Planning Application Ref: M/143/18/PL

Location: 66 Ancton Way, Elmer, Middleton-On-Sea, PO22 6JP

Description of works: Erection of a new 4-bedroom dwelling

Comments on Application:

<i>Client</i> Mr S. Shury			
<i>Project Title and Location</i> 66 Ancton Way Elmer, Bognor Regis			
<i>Drawing Title</i> Tree Retention and Protection Plan			
<i>Scale</i> 1:100@A1	<i>Drawn</i> LB	<i>Approved</i> JJ	<i>Date</i> 29.07.19
<i>Drawing No</i> LLD1758-ARB-DWG-002	<i>Revision</i> 00

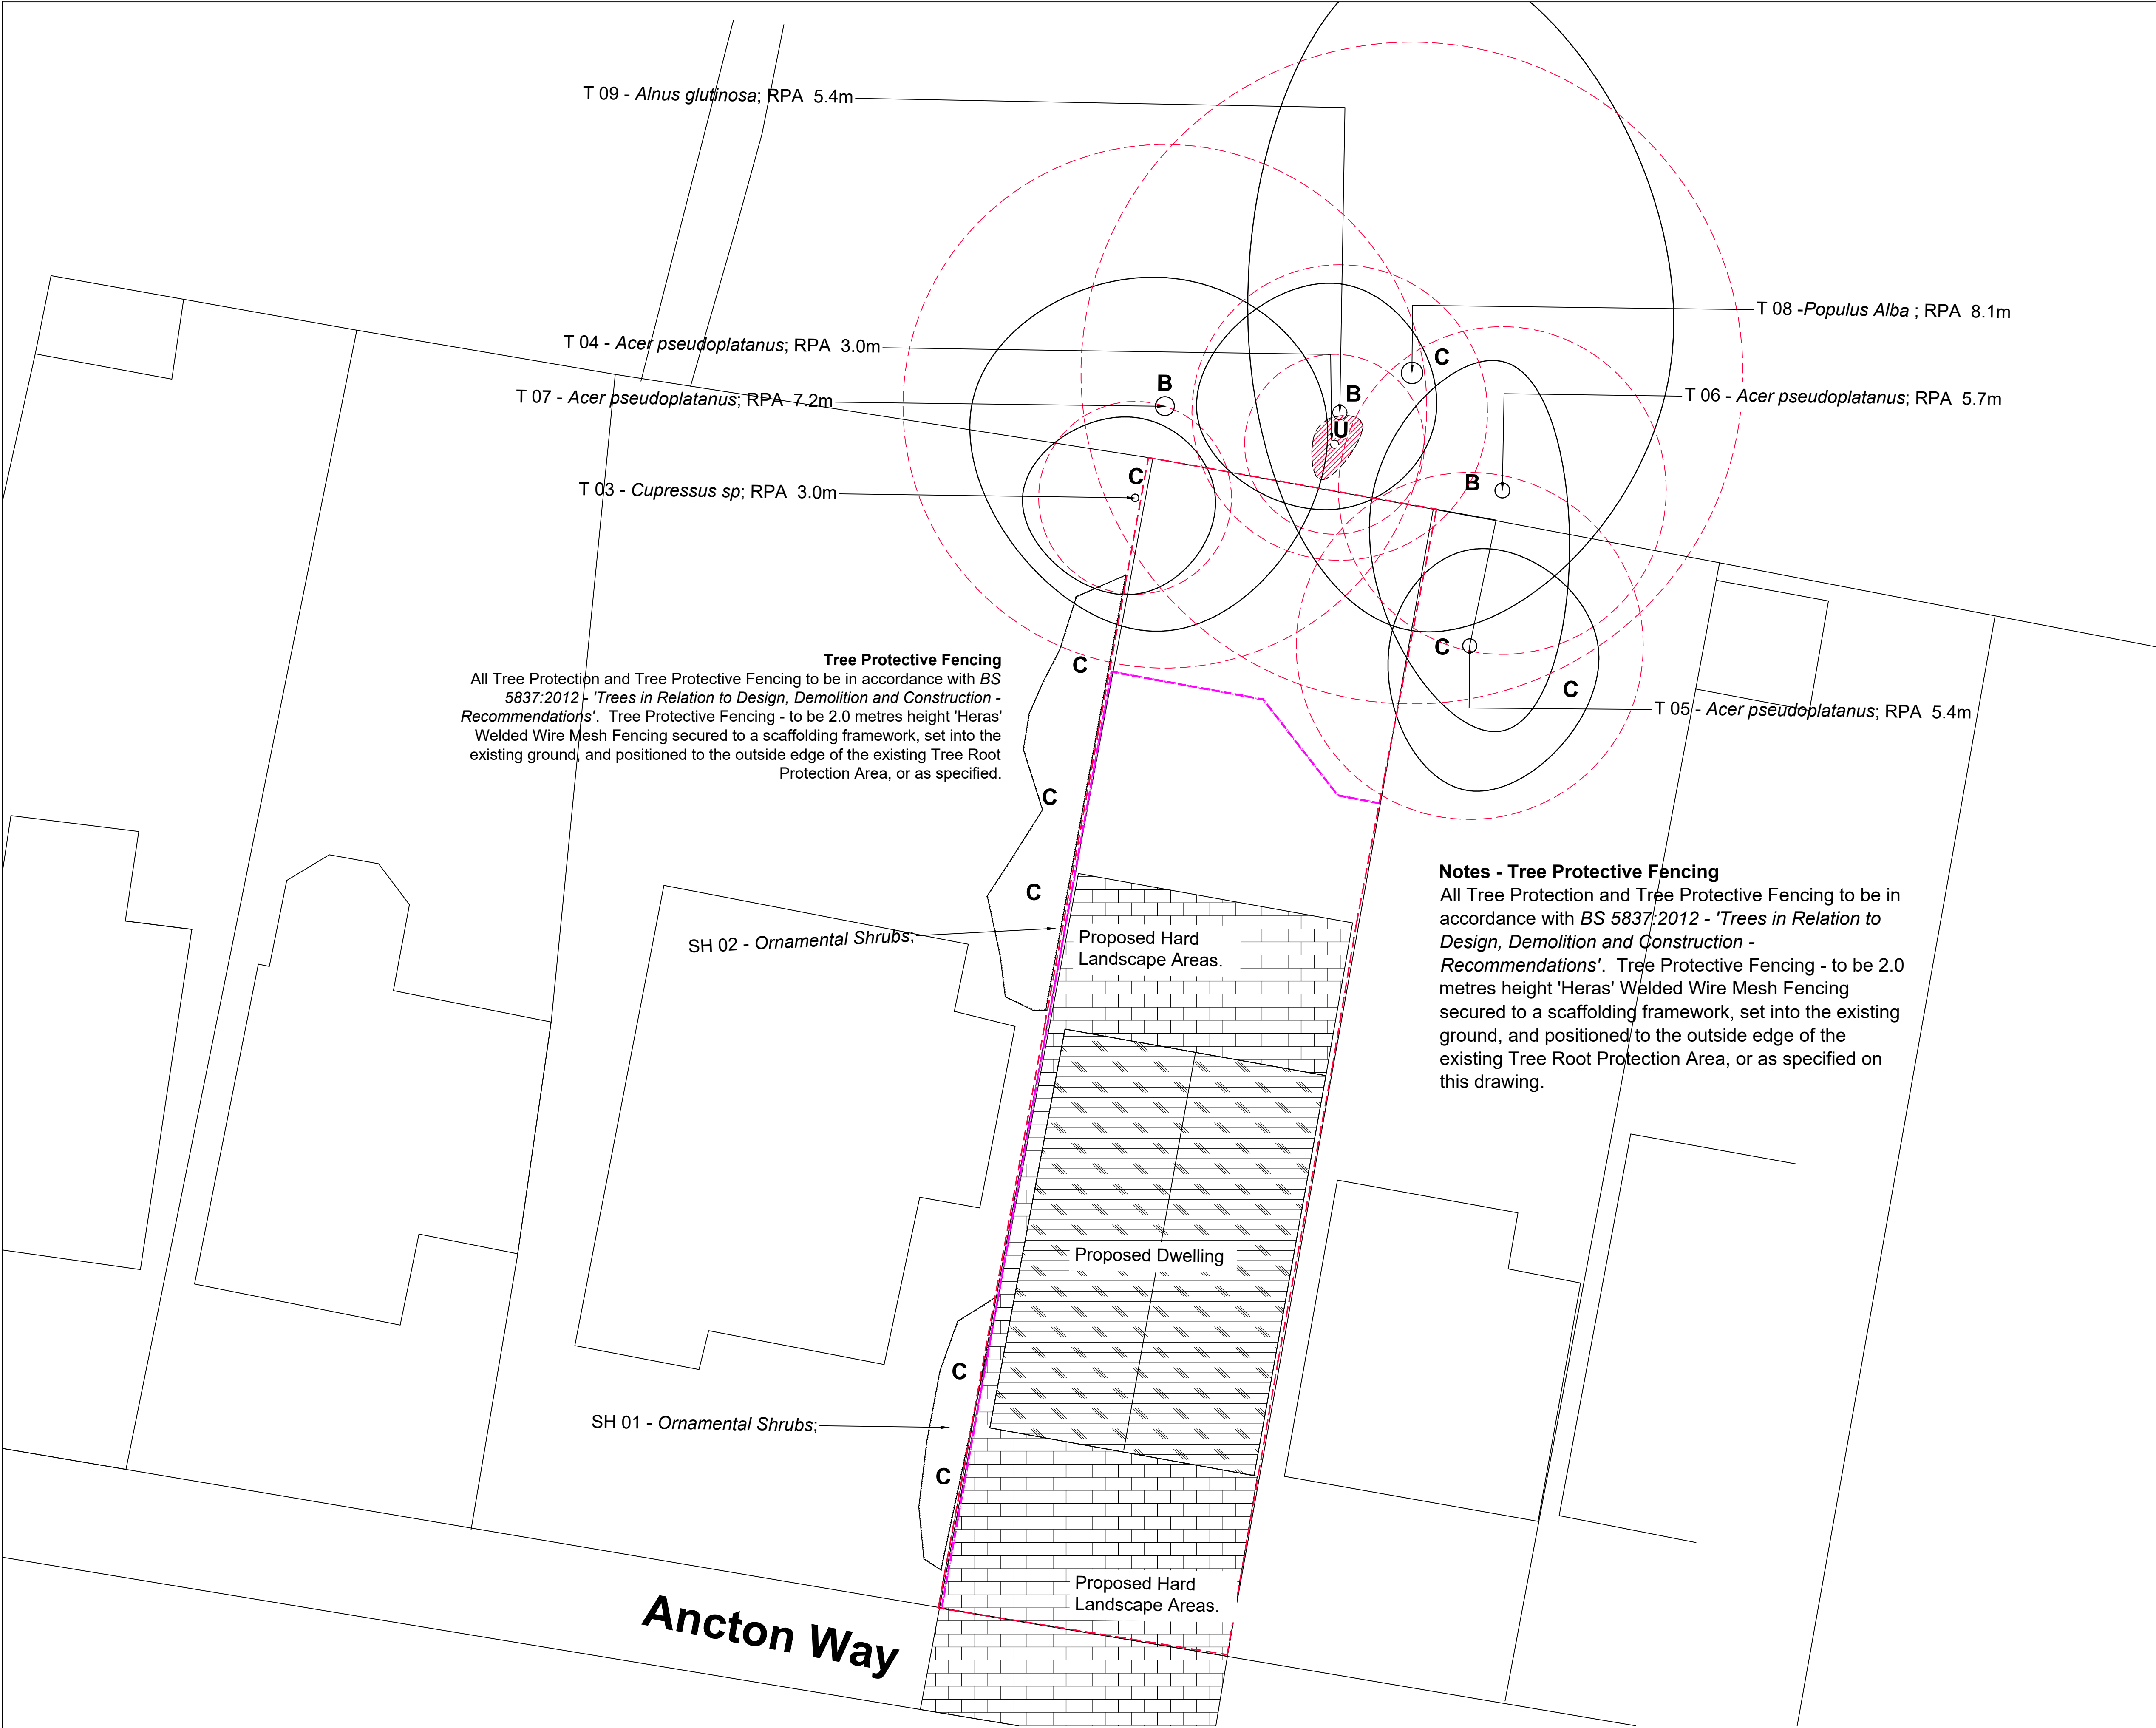
- The applicants have employed Lizard Landscape Design Ltd to prepare a Tree Survey Schedule along with Tree Constraints and Tree Retention and Protection Plans (TRPP) for this project.
- The Tree Survey data is comprehensive and accords with the requirements of BS5837:2012. I am in agreement with the retention category ratings for off-site trees. None have been retained within the plot.
- Significant trees overlapping the development are in woodland to the rear of the plot and enjoy statutory protection (TPO/M/1/91). These will be adequately protected by the installation of fencing as described in the TRPP.

- I recommend **APPROVAL** for this scheme subject to the following condition being applied:
- Before the site is occupied or any machinery is introduced to the site or demolition work or construction work or alterations to existing ground levels takes place the Arboricultural Expert representing the site owner(s) must provide the local planning authority with written evidence by way of a report with attached photographs demonstrating that all protective fencing has been inspected to verify it is 'Fit for Purpose' as required under British Standard 5837:2012 and been erected and positioned exactly as shown on the **Tree Retention and Protection Plan, dwg.no. LLD1758-ARB-DWG-002, Rev 00.**
